**WEST SUSSEX COUNTY COUNCIL
STRATEGIC PLANNING CONSULTATION**

SUBJECT: BR/239/14 - 1 no illuminated (solar panel) pole mounted board sign.

Corner Of, West Street/ Scott Street, Bognor Regis, PO21 1UH

Block Plan
Scale 1:500

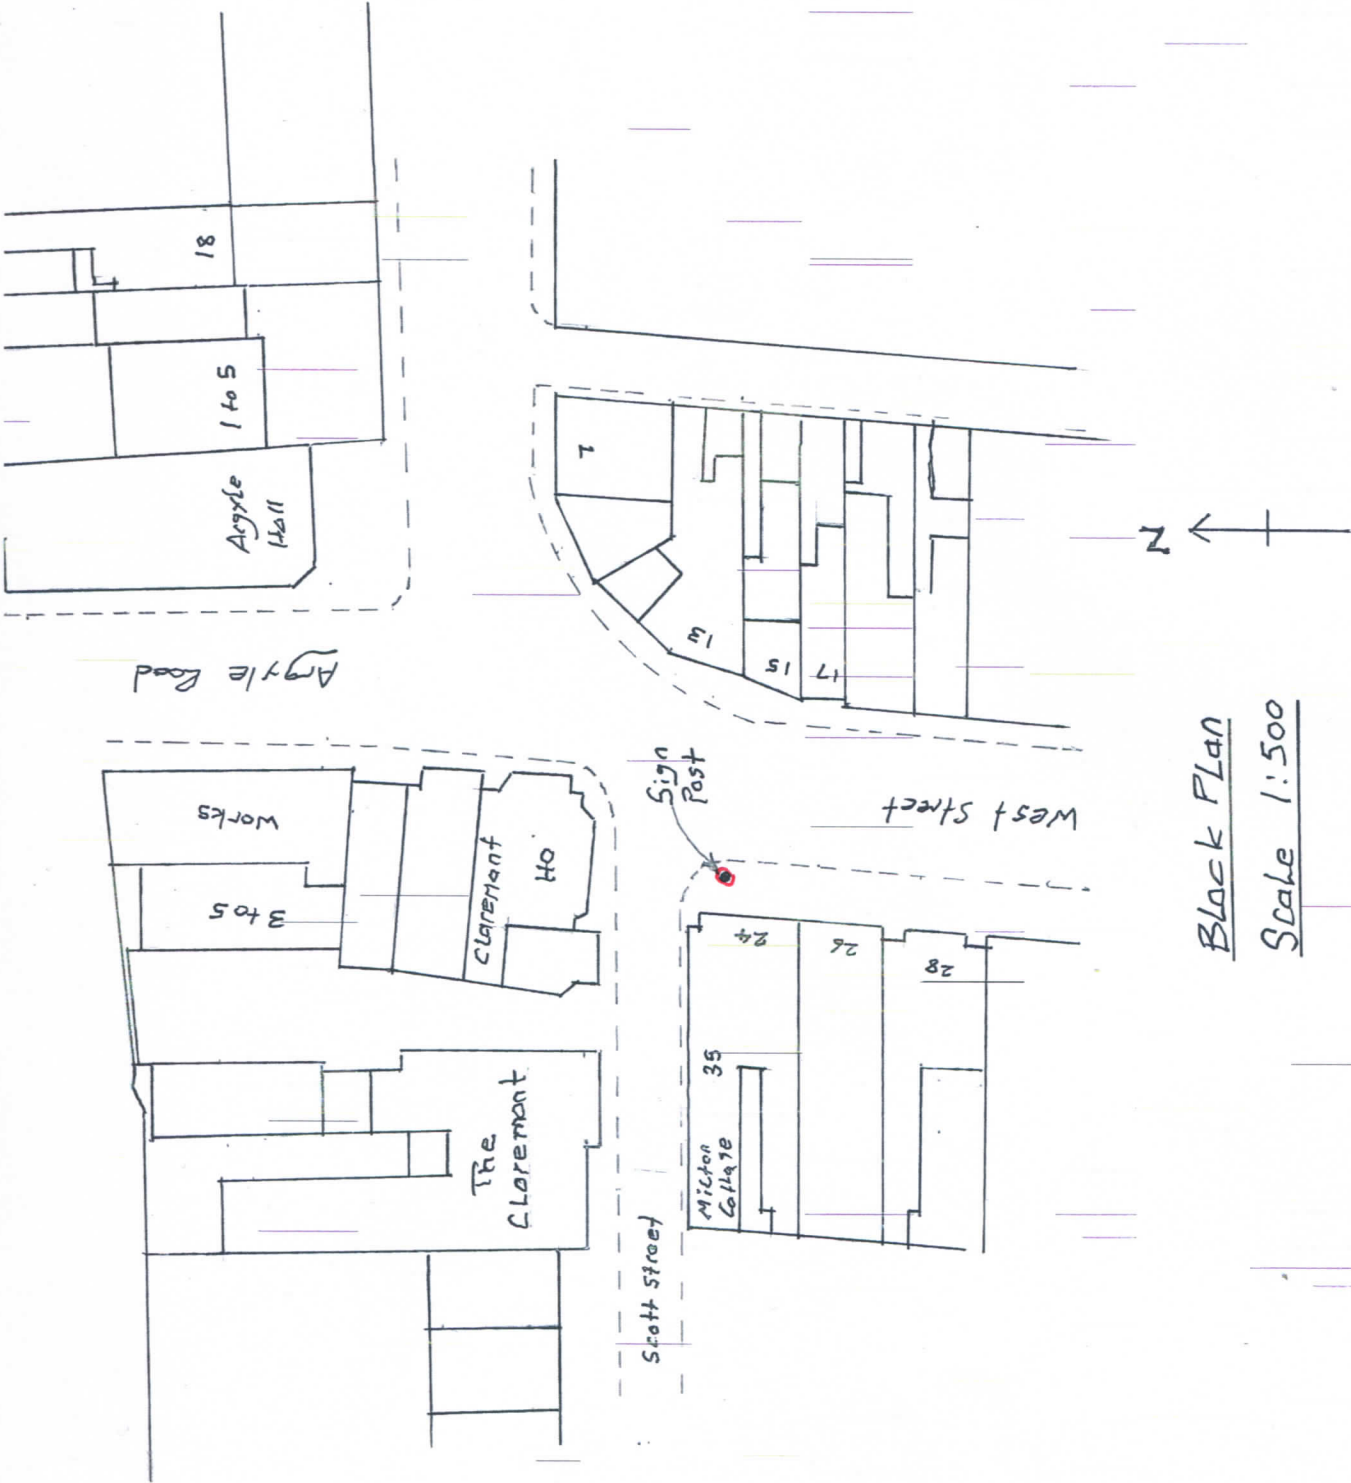
The application seeks approval for the erection of an illuminated pole mounted board sign on the footway next to the junction of Scott Street and West Street. According to current records held at WSCC, this sign is proposed within the public highway. The Highway Authority, therefore, would not be in a position to support this proposal. In order to overcome this reason for objection, I would recommend that the applicant reposition the sign outside the public highway and away from a position that would impede on vehicular visibility.
